Application number: 2024/93410	
What is the application for?:	Erection of single storey rear extension
Address of the site or building:	629, Hunsworth Lane, East Bierley, BD4 6PU
Postcode:	BD4 6PU

DRG No 241141

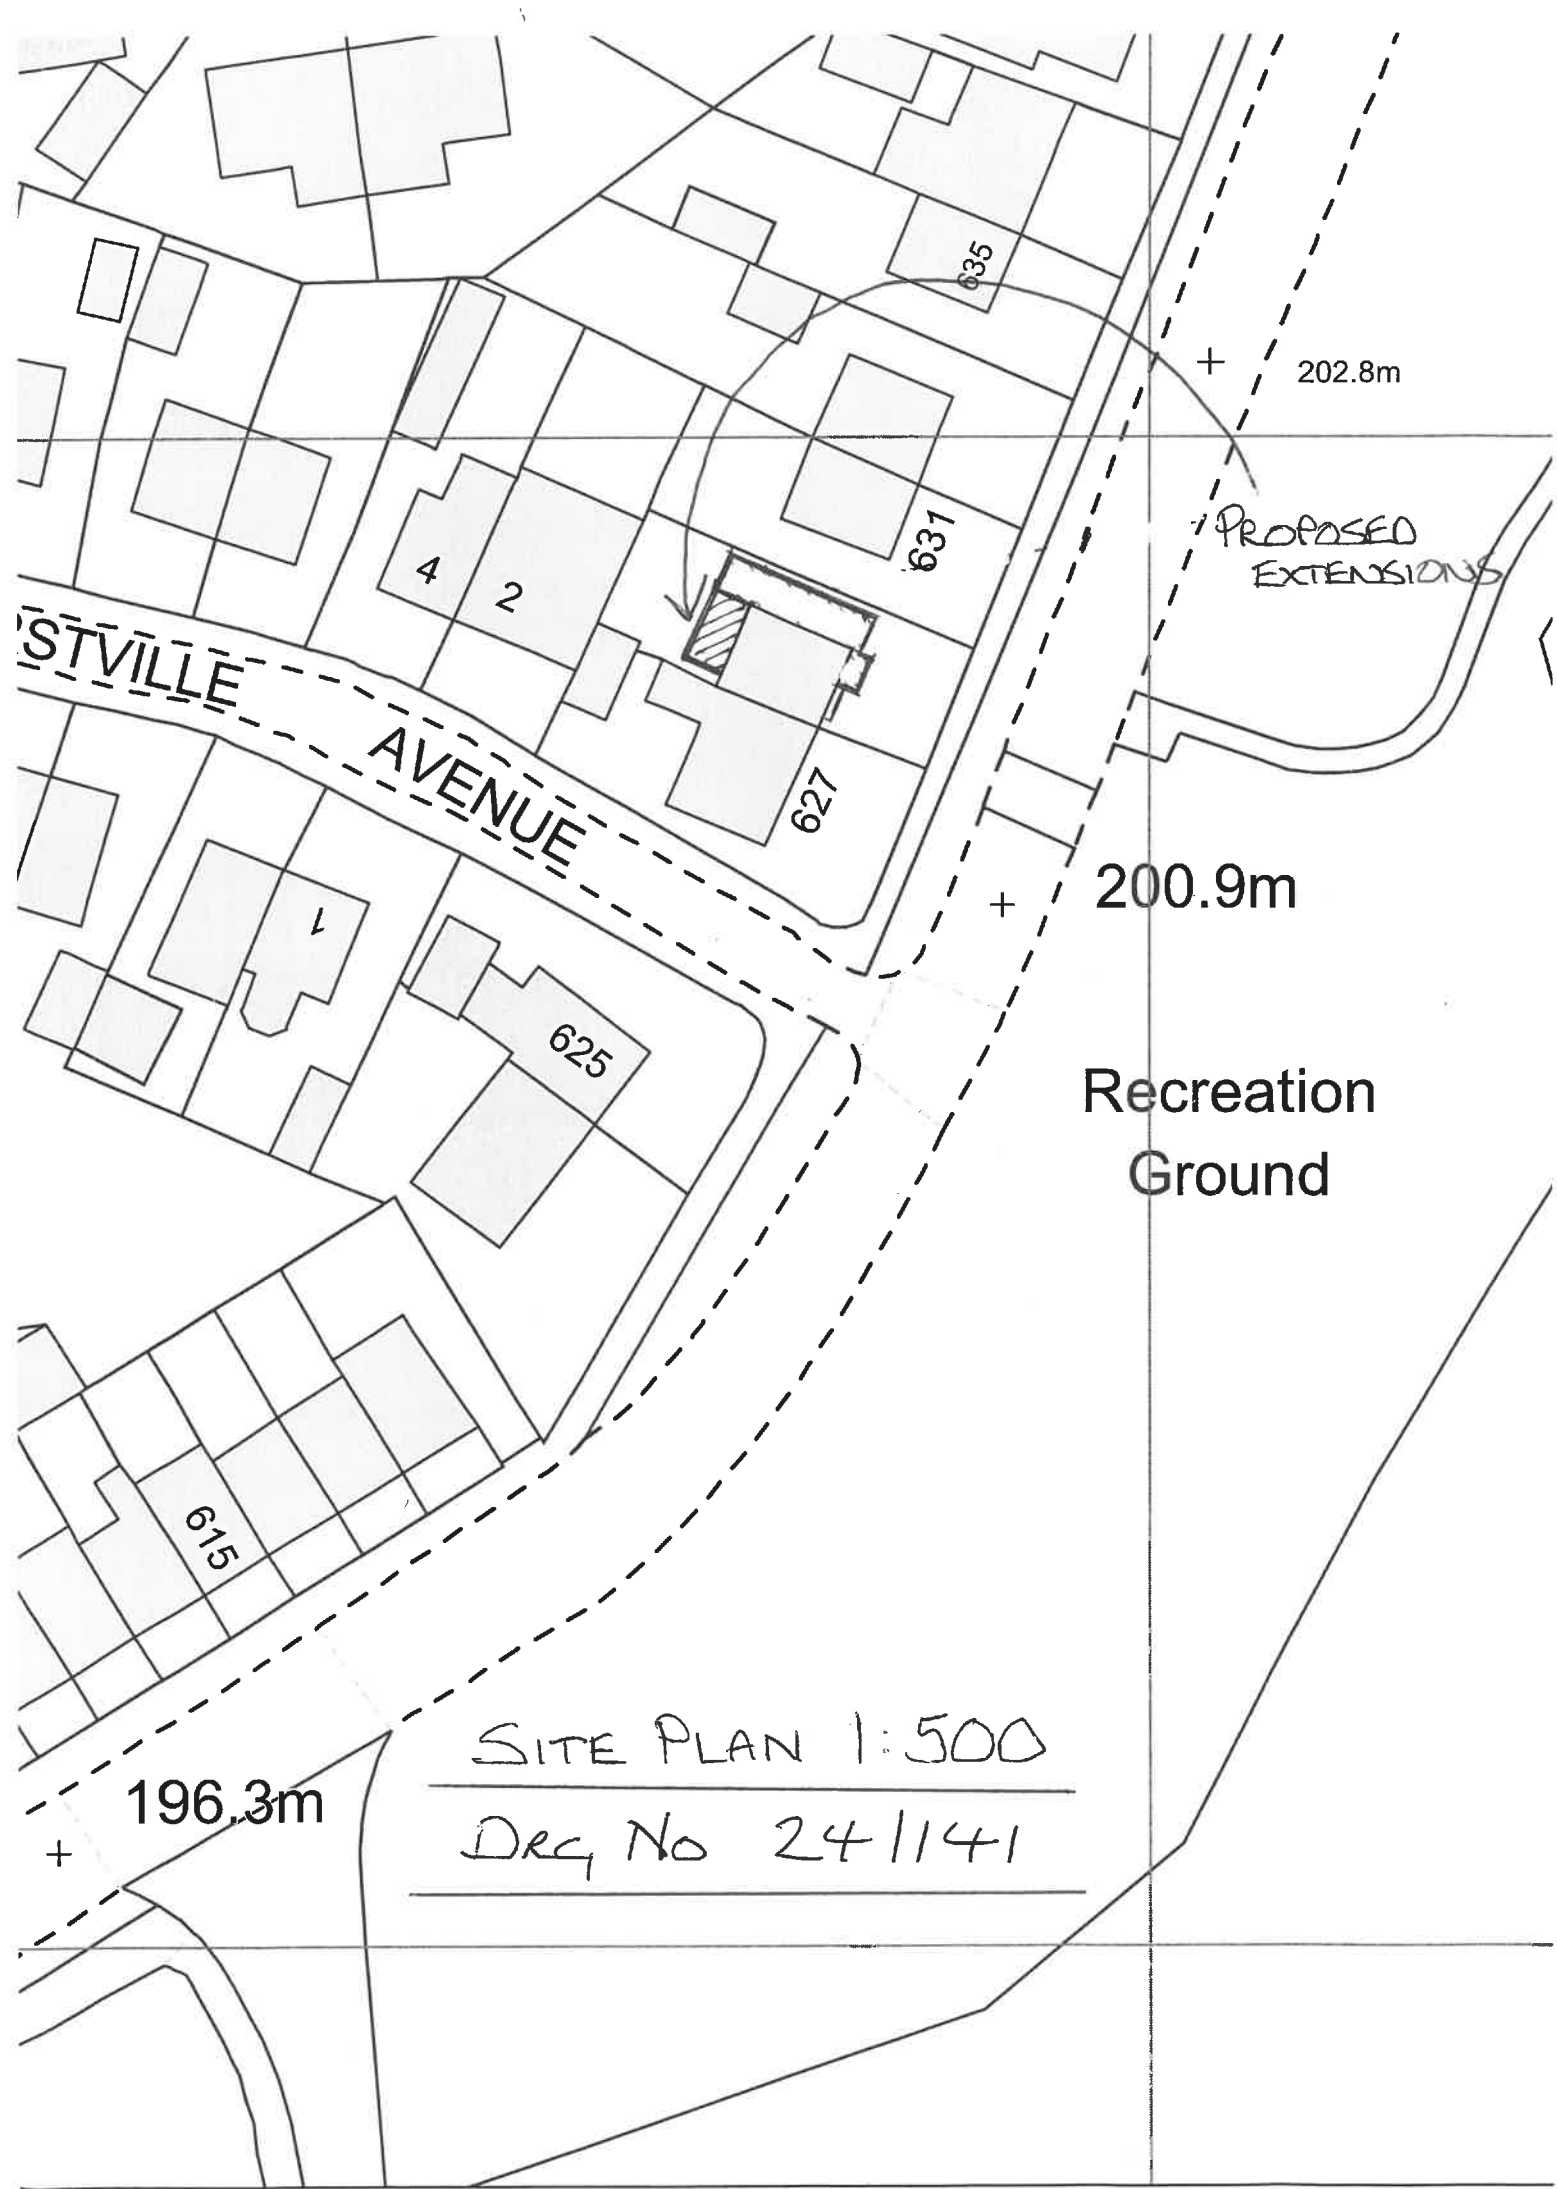
Type of comment: An objection	
Do you wish your comments to be published on the website anonymously?	Yes
<p>Our kitchen wall runs along the boundary . We have an extractor fan which vents from this wall and we are concerned that the wall of the proposed extension will block the vent's function and the plan indicates that there will not be sufficient clearance for assess, maintenance or replacement. Please will you clarify how much clearance there will be between our wall and the wall of the proposed extension at no.629?</p> <p>The plan indicates that there is a down pipe on the corner of the proposed extension nearest to our property. A blocked gutter here could result in the overflowing water pouring down our kitchen wall which may result in a damp issue behind our kitchen units. Again the distance between our existing building and the proposed extension is not indicated on the plan.</p> <p>We are concerned that scaffolding erected during the building of the proposed extension will damage our walls. Also that digging the foundations of the proposed extension may adversely affect the foundations and footings of our kitchen (which is an extension to the original house).</p>
